Ribchester Parish Council

PLANNING APPLICATION No: 3/12/0294 and 295

Application: Proposed demolition of single storey extension to be replaced with a two storey extension [resubmission]

At: 12 & 13 MANOR AVE. RIBCHESTER

Proposed Ground Floor Layout

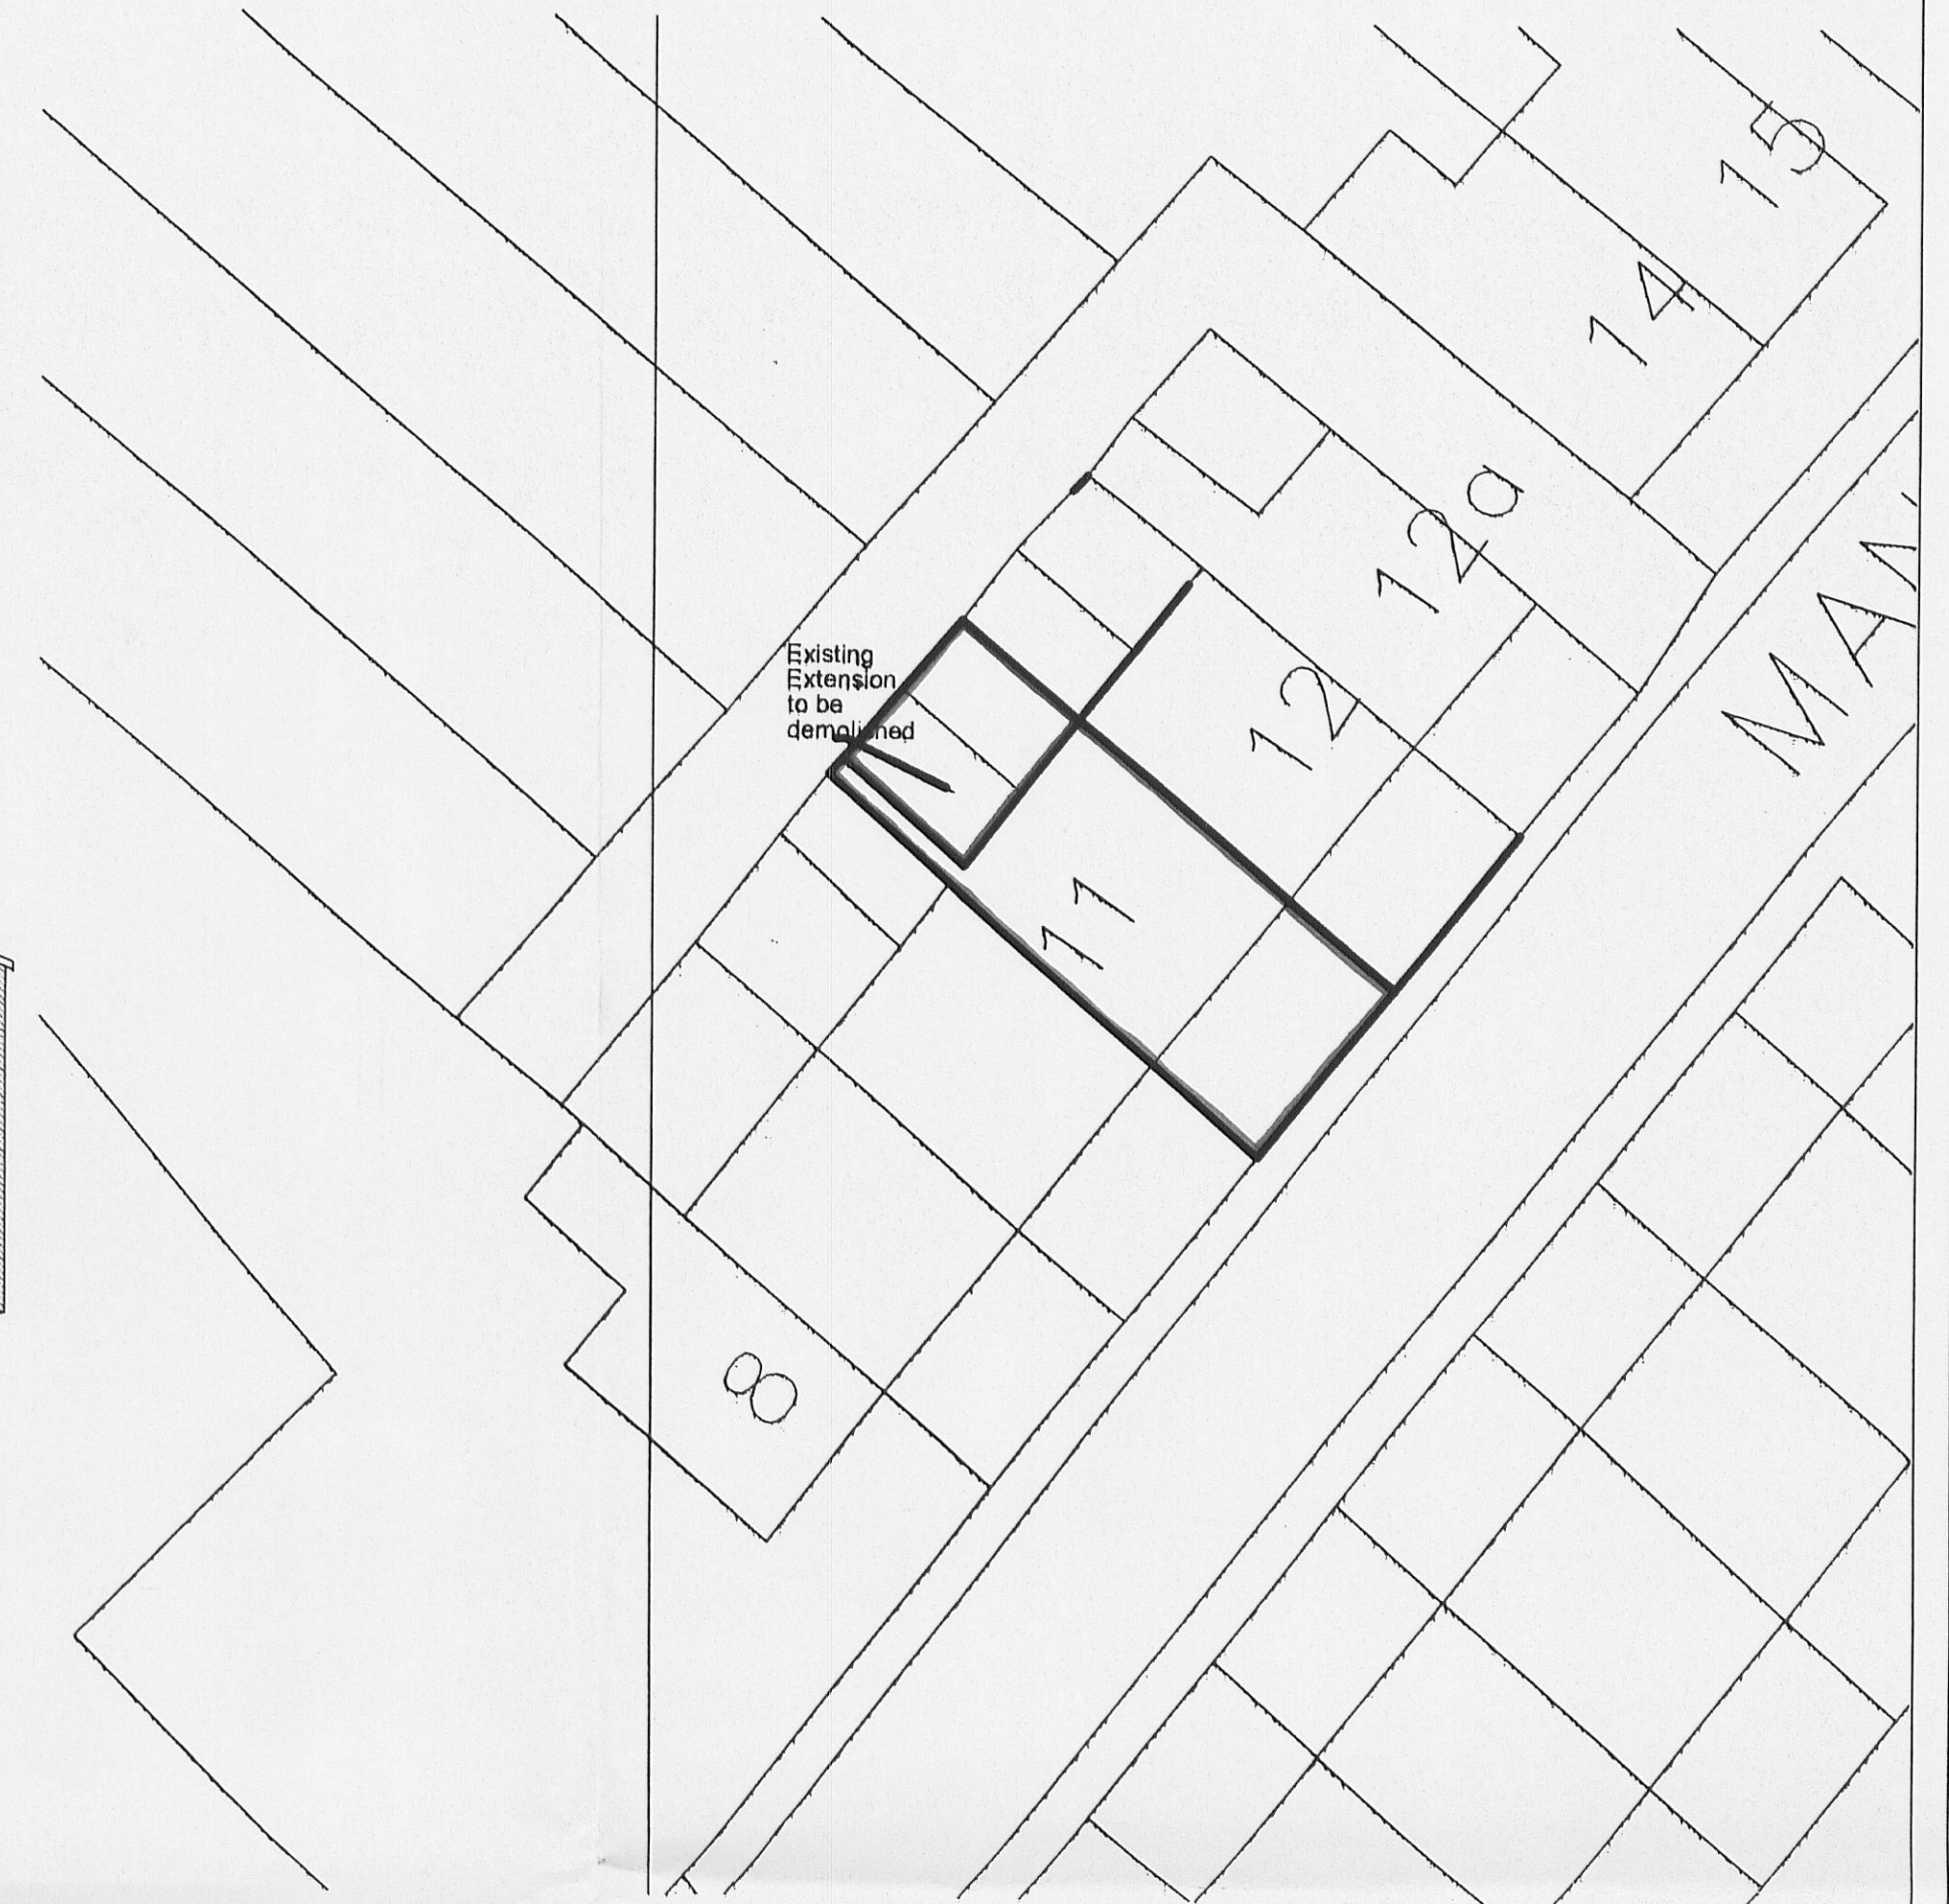
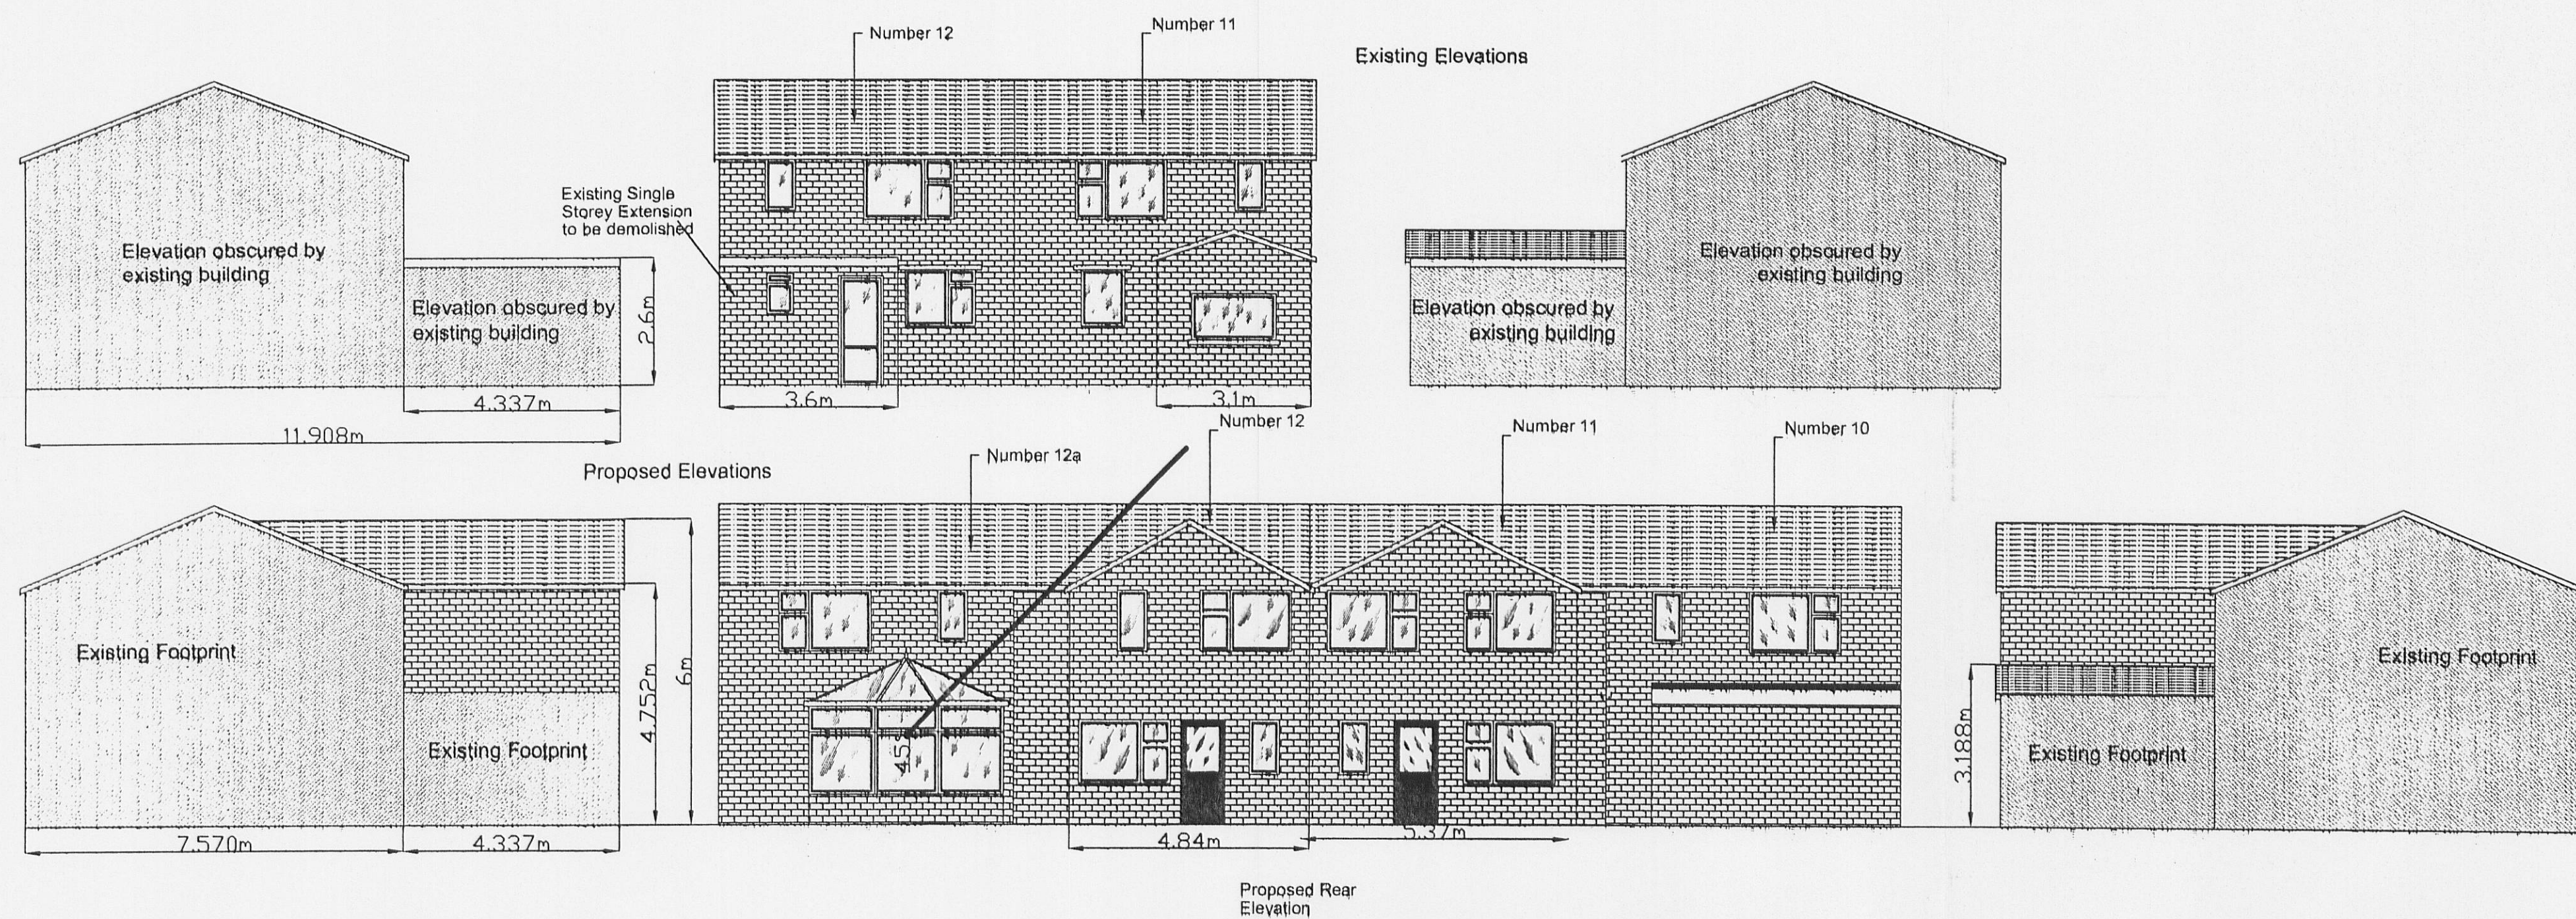
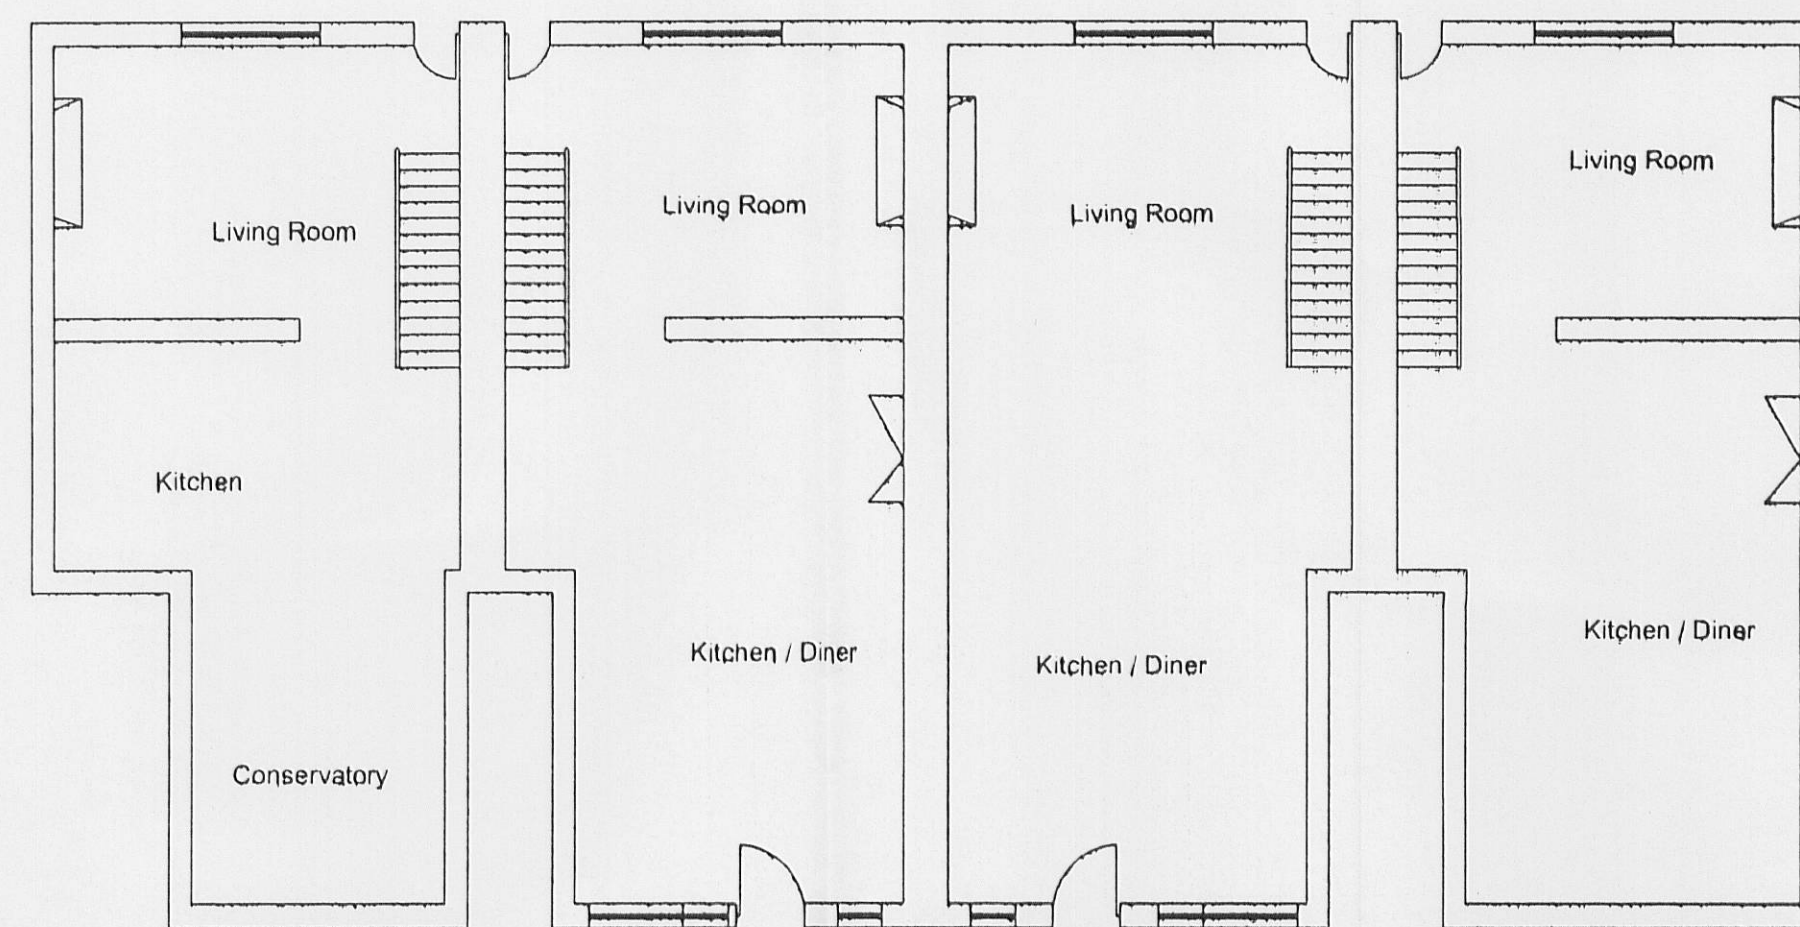
The Parish Council notes that the two original applications were refused by planning officers on the grounds that the proposals were harmful to the amenity of neighbouring residents as a result of the overbearing nature of the developments and the loss of light. The present applications as now submitted show such minimal adjustments to dimensions that the initial conclusion remains pertinent.

While the Parish Council did not object to the original applications it now takes the view that the proposals would result in significant harm to the amenity of neighbouring properties and, therefore **OBJECTS** to the applications.
